Our Reference: 25/1174

**RE: Proposed Central Coast Regional Cancer Centre
Gosford Hospital Cnr Holden Street and Racecourse Road GOSFORD NSW
2250
Part 3A Major Project MP10_0173
Assessment of Accessibility for People with Disabilities**

The following drawings were reviewed: DOP06 (02), DOP 06 (02), prepared by Silver Thomas Hanley Health Architecture to confirm access for people with disabilities to be provided throughout the site.

DRG No: DoP 04
REVISION: 02

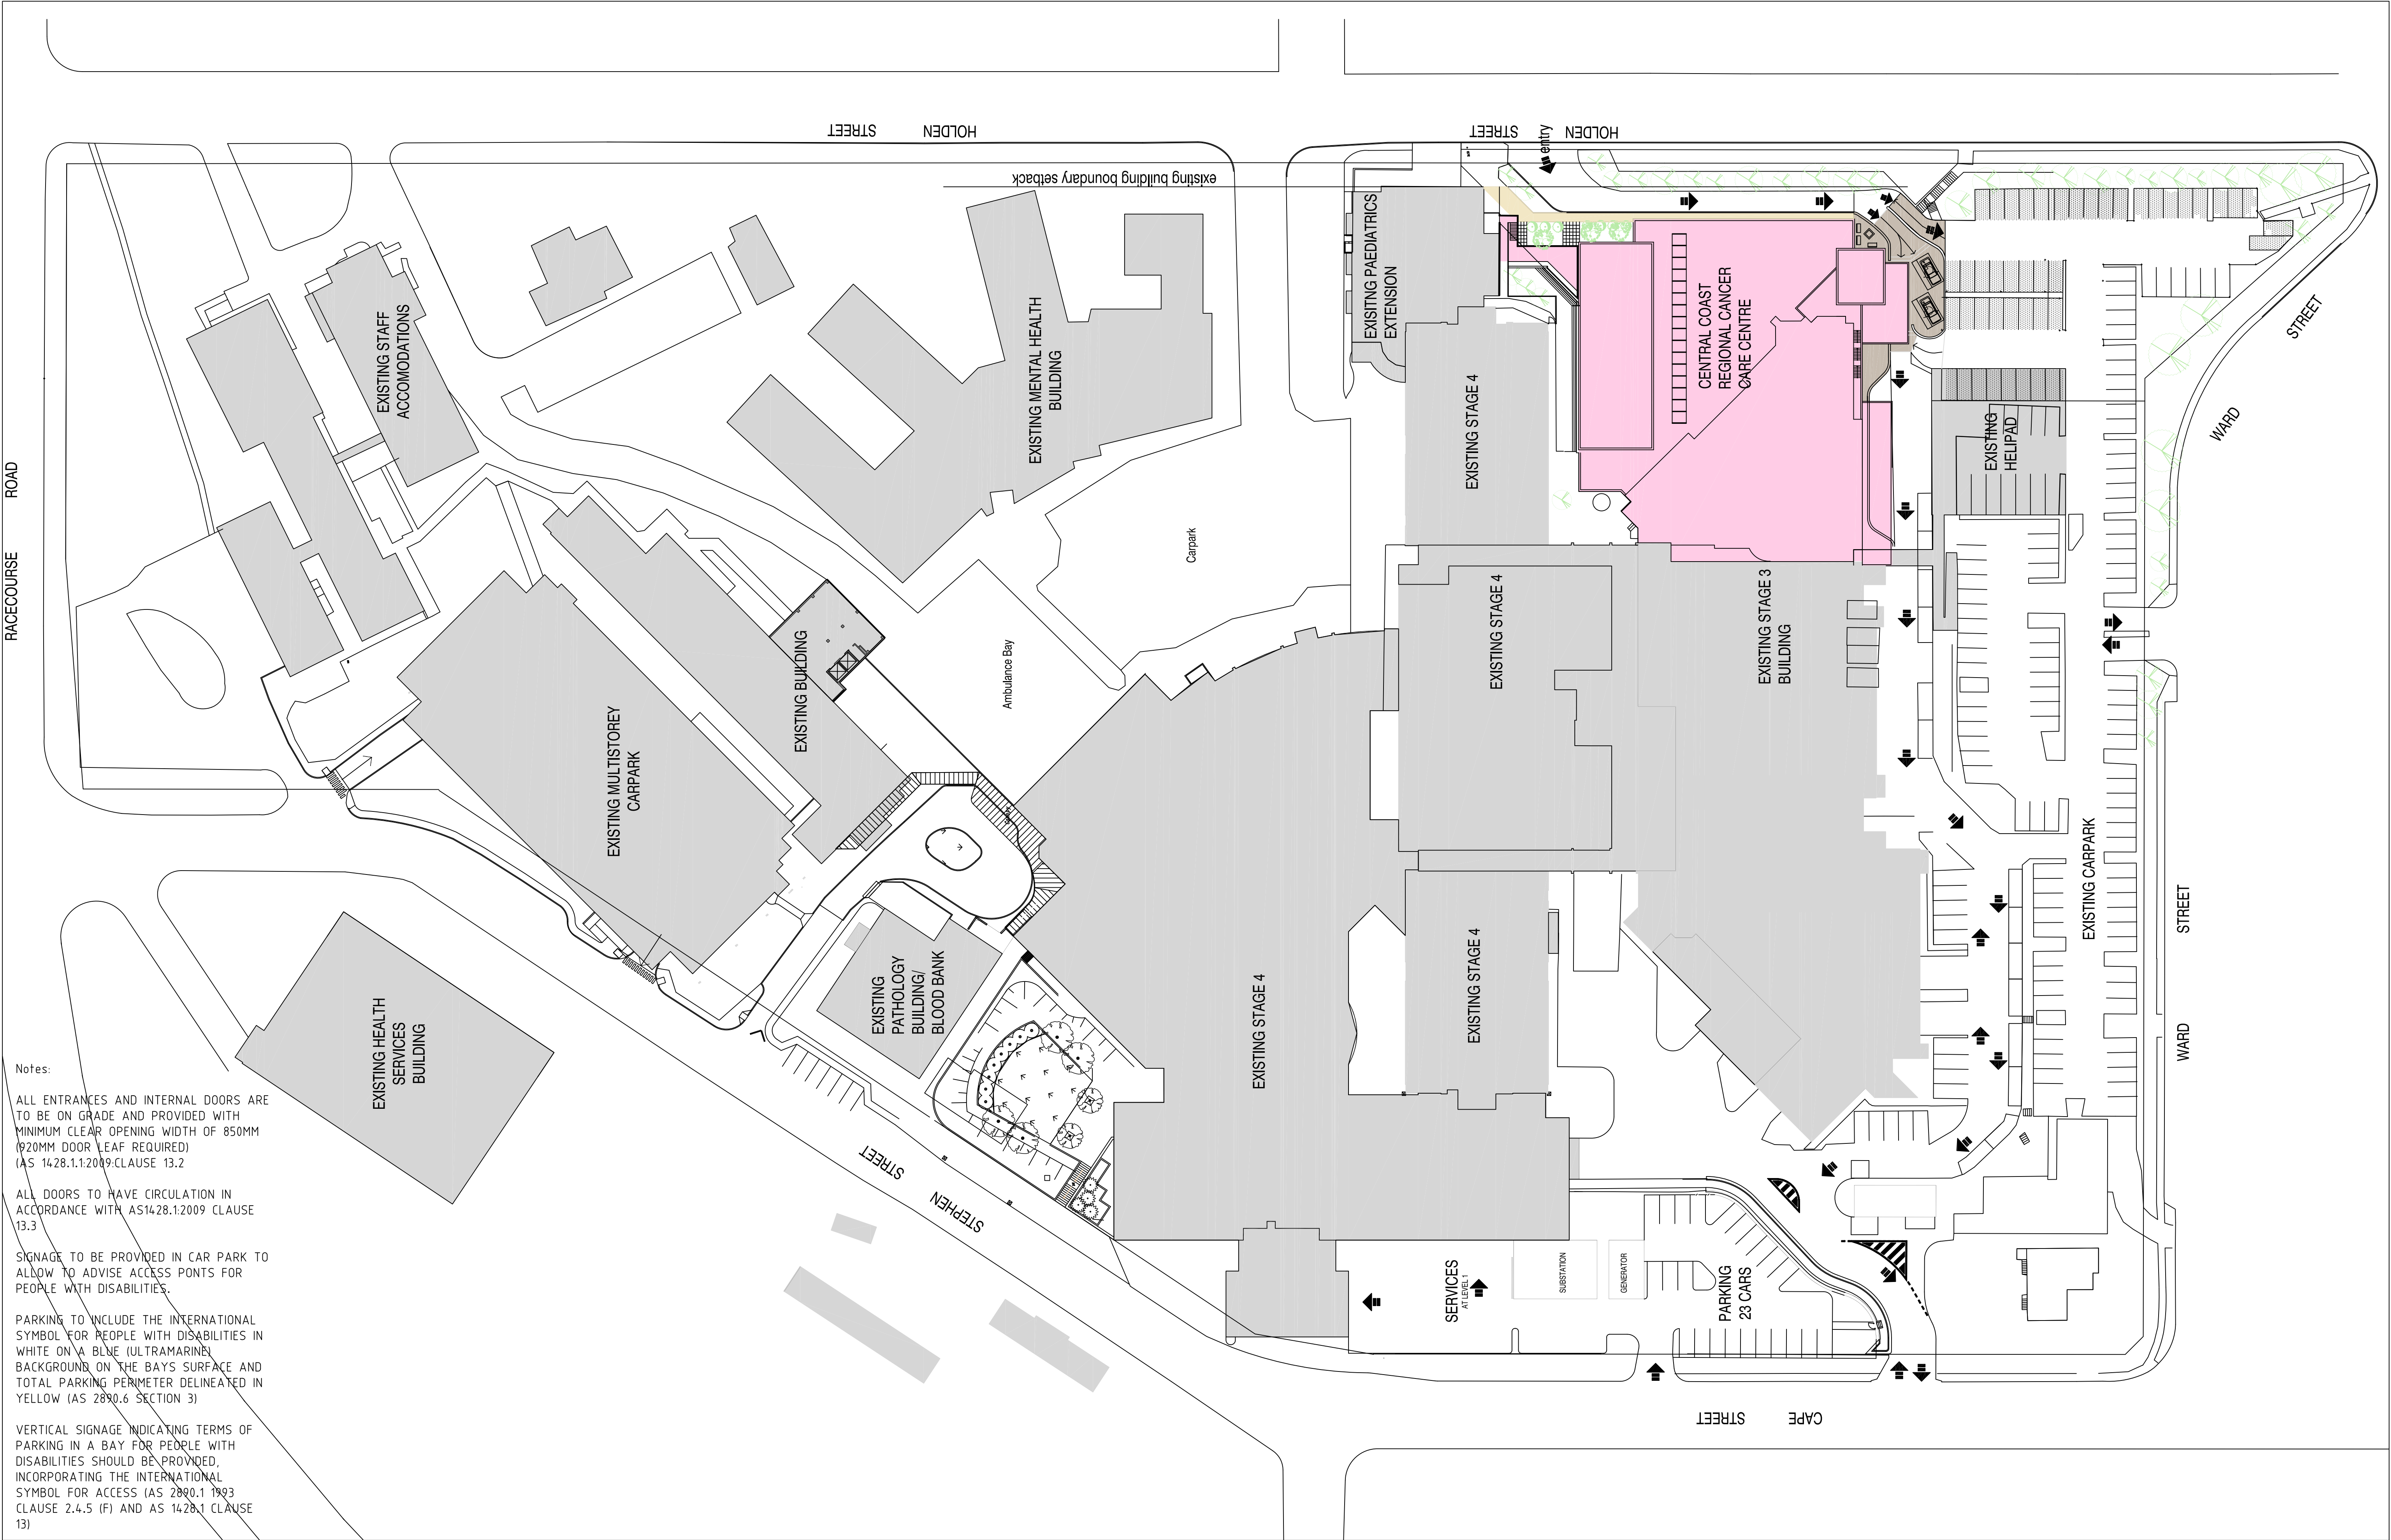
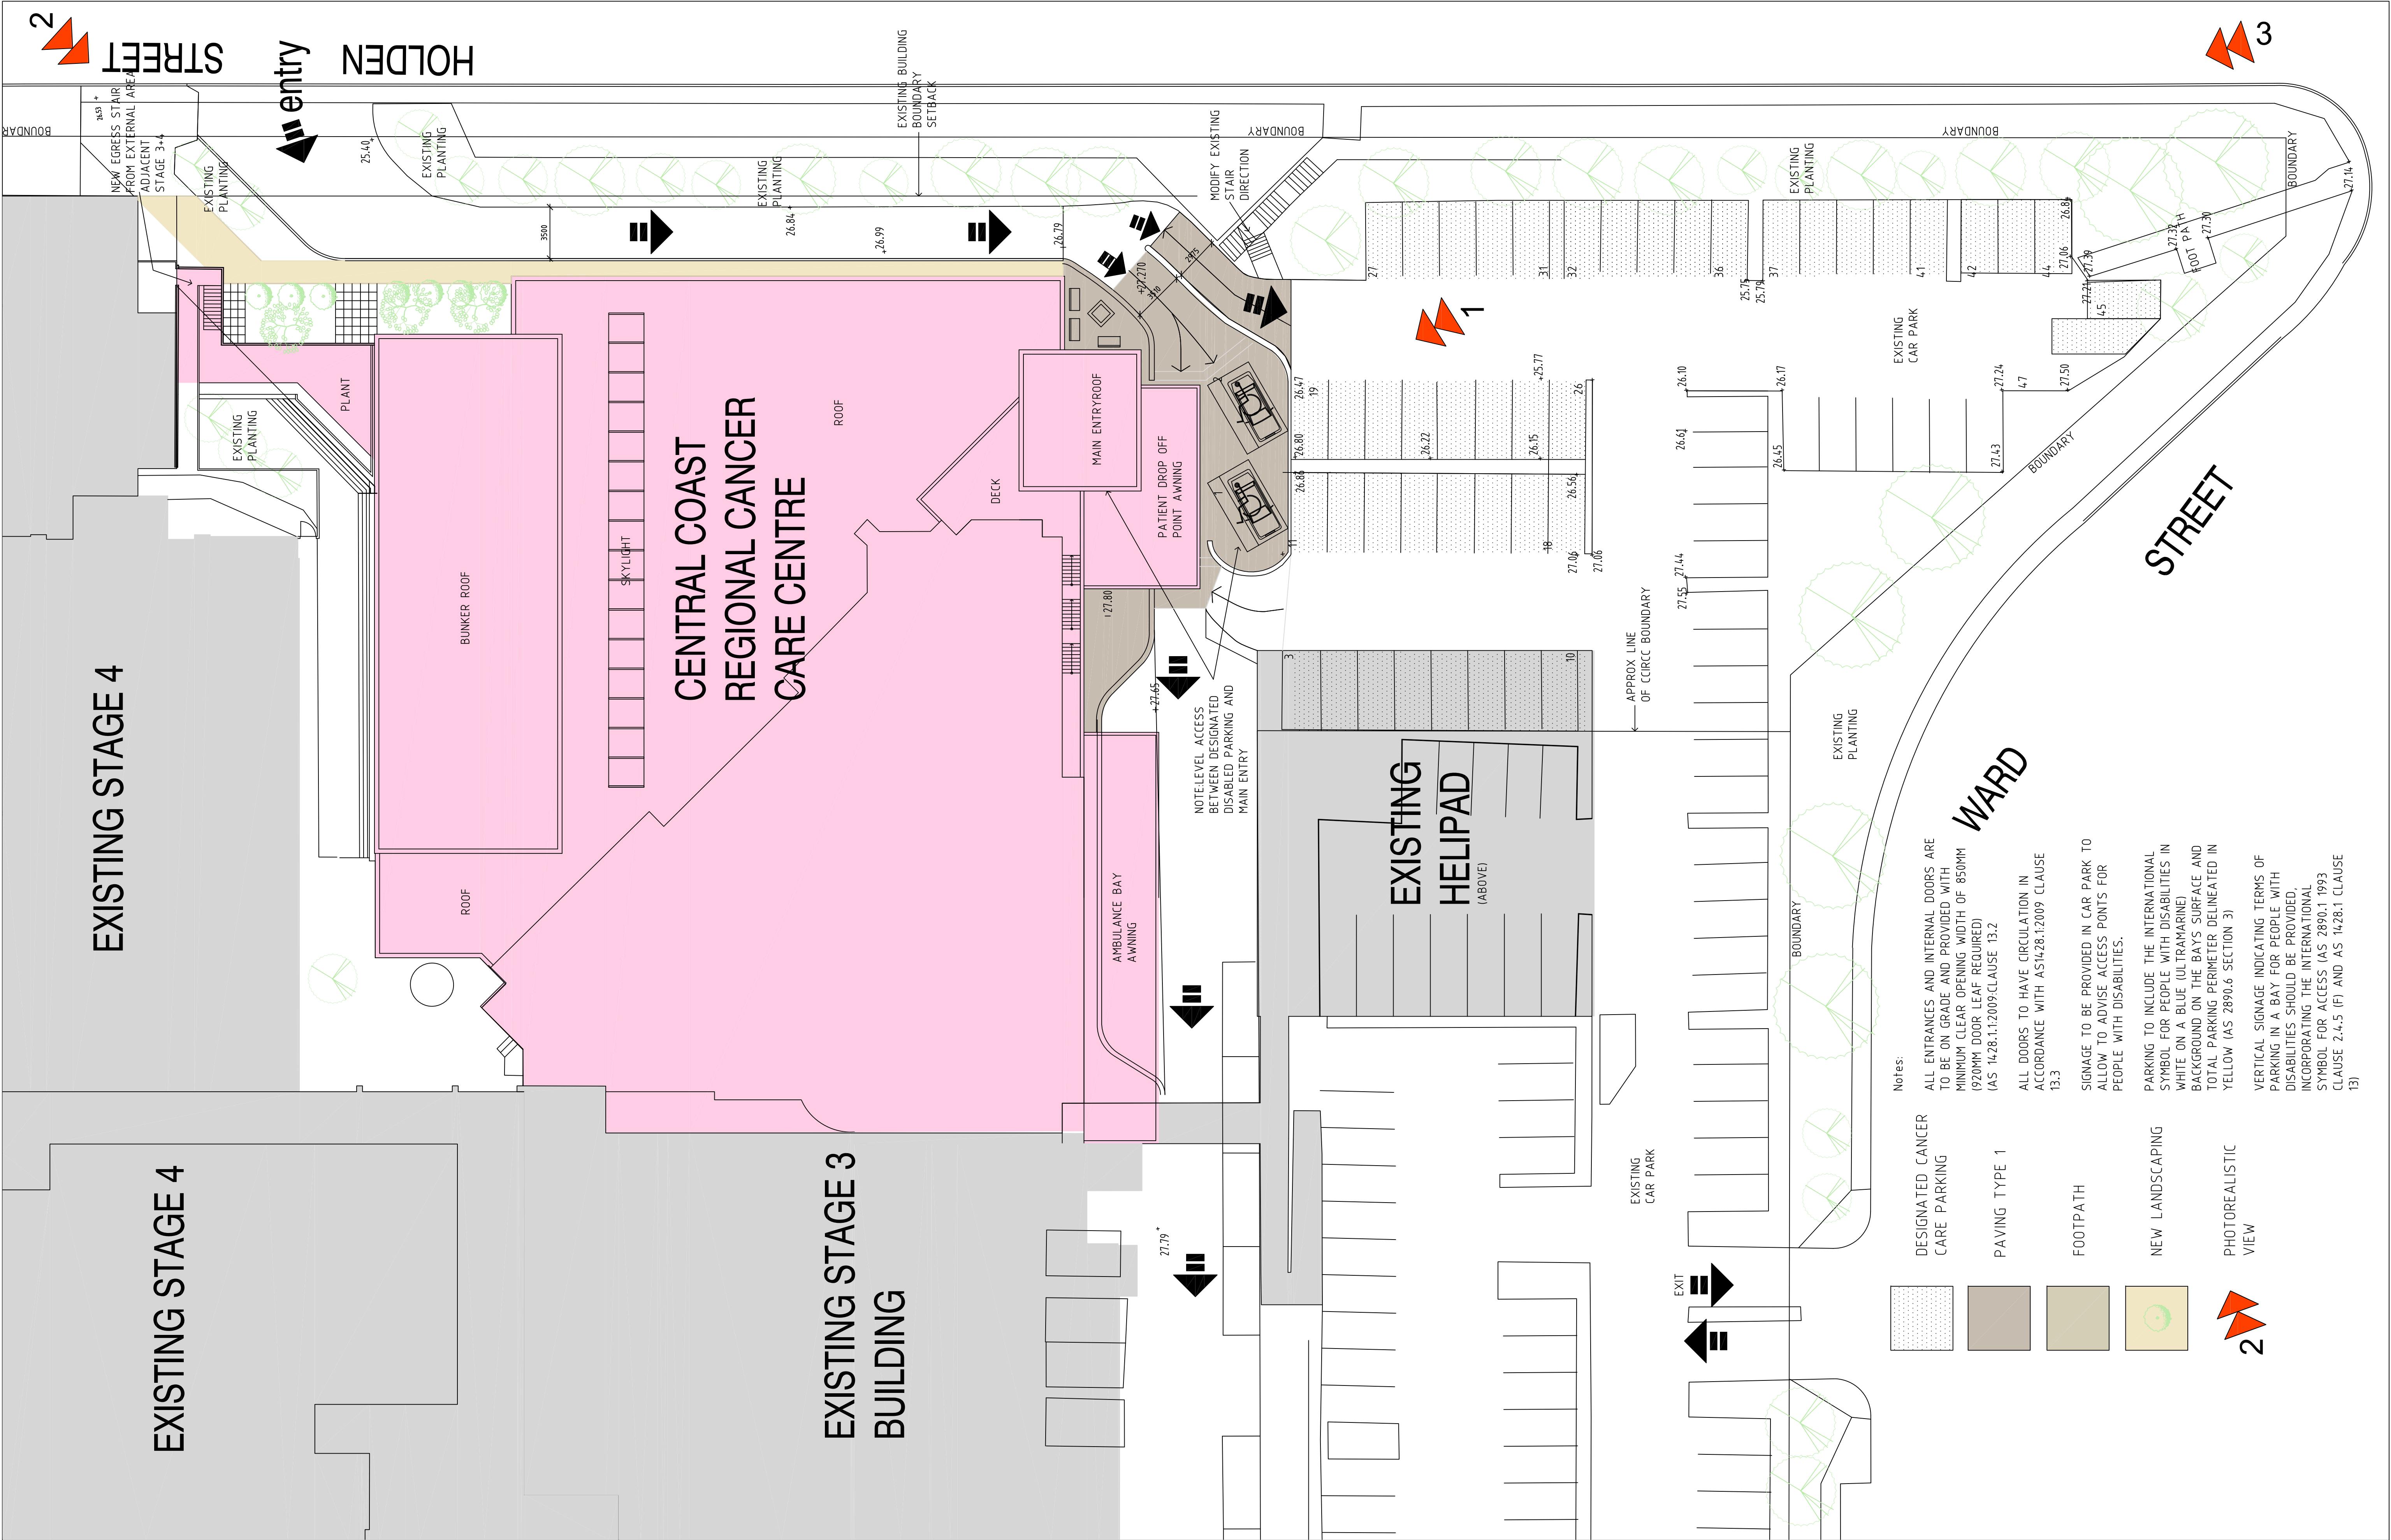
A total number of 46 additional car parking spaces are provided to the site, with two designated parking bays for people with disabilities provided centrally to the main entrance. The spaces have appropriate dimensions of 3200mm x 5400mm as per the relevant Australian Standard.

A continuous accessible path of travel with minimum width of 1800mm is provided from Cancer Centre Entry.

- The total perimeter of the accessible parking area shall be delineated in blue / yellow. Bays for people with disabilities should be an alternative colour to the predominant colour used for general bays (AS 2890.1:2004 Clause 4.4.1, AS2890.5:1993 Clause 4.5.2 Notes: 2, DDA).

- Each dedicated space shall include the international symbol for access in white on a blue (Ultramarine) rectangle with no side more than 1200mm. It shall be located on the bays surface, in the centre of the dedicated space between 500mm and 600mm from the roadway end of the bay (AS 1428.1 Clause 14.2; AS 2890.6:2009 Clause 3.1).

- Parking spaces are located externally; therefore the maximum gradient of the dedicated space and adjacent shared space shall not exceed 1:40 or 1:33 if the surface has a bituminous seal.

A continuous accessible path of travel, with minimum width of 1500mm is proposed from the allotment boundary (Holden and Ward Street) and accessible parking bays to the main entrance. Passing areas are generally provided to enable two wheelchair users to pass with a couple of areas as stated previously.

The main entrance to the centre consists of an automatic door which provides appropriate clear opening width of 850mm for people with disabilities. The approach to the entrance will be at 1:40 grade that provides a clear, level landing area on both sides of the door for wheelchair maneuvering and for ambulant people using mobility aid.

The proposed internal doors will achieve a clear opening of no less than 850mm wide (920mm door leaf) and are provided with appropriate circulation space for their operation with the exception of. This is noted on the drawings.

There is one unisex accessible sanitary facility for people with disabilities provided for staff and visitor use. The facility is located adjacent to the gender facilities adjacent to the reception. The internal dimensions of this facility are appropriate at 2100mm x 2700mm. The fixture placement will ensure clear circulation of 1900mm X 2300mm to the pan. The washbasin will not encroach more than 100mm into this space.
